**From:** Jeromy Hicks <jeromy.hicks@mercergov.org>  
**Sent:** Friday, July 1, 2022 12:15 PM  
**To:** Bree Medley  
**Cc:** Stephen Mair; Andrew Leon  
**Subject:** RE: 2011-147\_REV1

**From:** Bree Medley <bree@brandtdesigninc.com>  
**Sent:** Thursday, June 30, 2022 2:24 PM  
**To:** Jeromy Hicks <jeromy.hicks@mercergov.org>  
**Subject:** 2011-147\_REV1

1
1" = 10'-0"
PROPOSED SITE PLAN

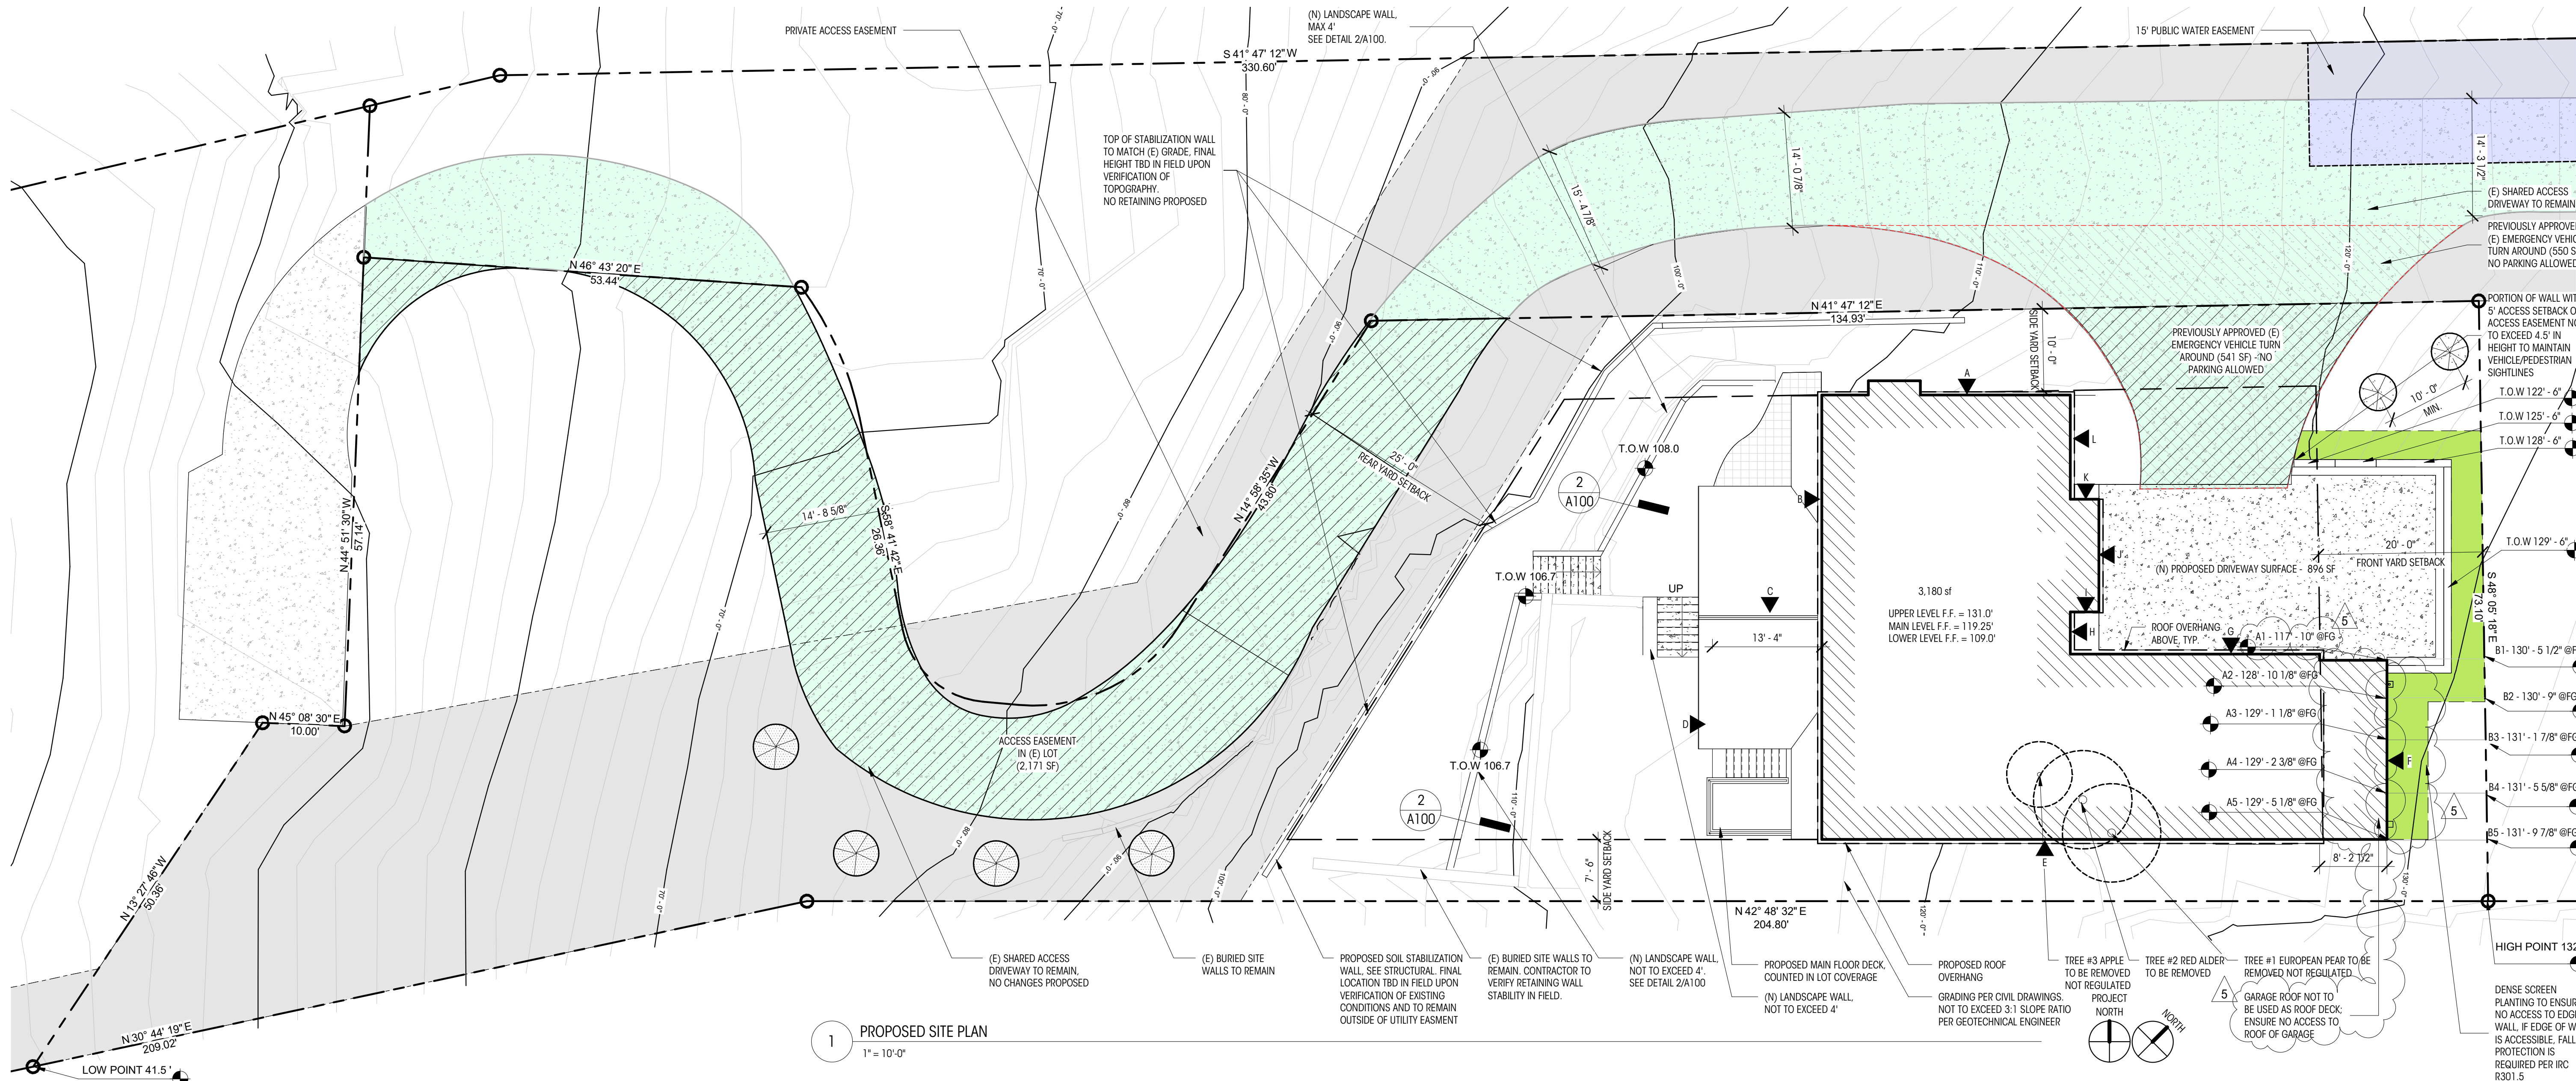
We received a plan check comment from Andrew Leon regarding something that was previously approved and I am hoping that an email confirmation from you will suffice. Given the steep slope of this property we have site walls adjacent to the vehicle access easement (no change from previously approved permit) and we are now being asked to demonstrate that they do not interfere with emergency vehicle access or sight distance for vehicles. I have attached the site plan and elevation showing the grade at the mouth of the driveway along with the wall heights within the 5' setback. We are under 4' in height at the driveway mouth apron. Can you please let me know if there are any fire department concerns with this?

I took a look at the permit. You have a approved Code Alt on file that mitigates the roadway width, slope and turn-around. We did discuss the entrance the driveway and that was taken in to account with the code alternatives that you proposed. We are fine with the previously approved plans.
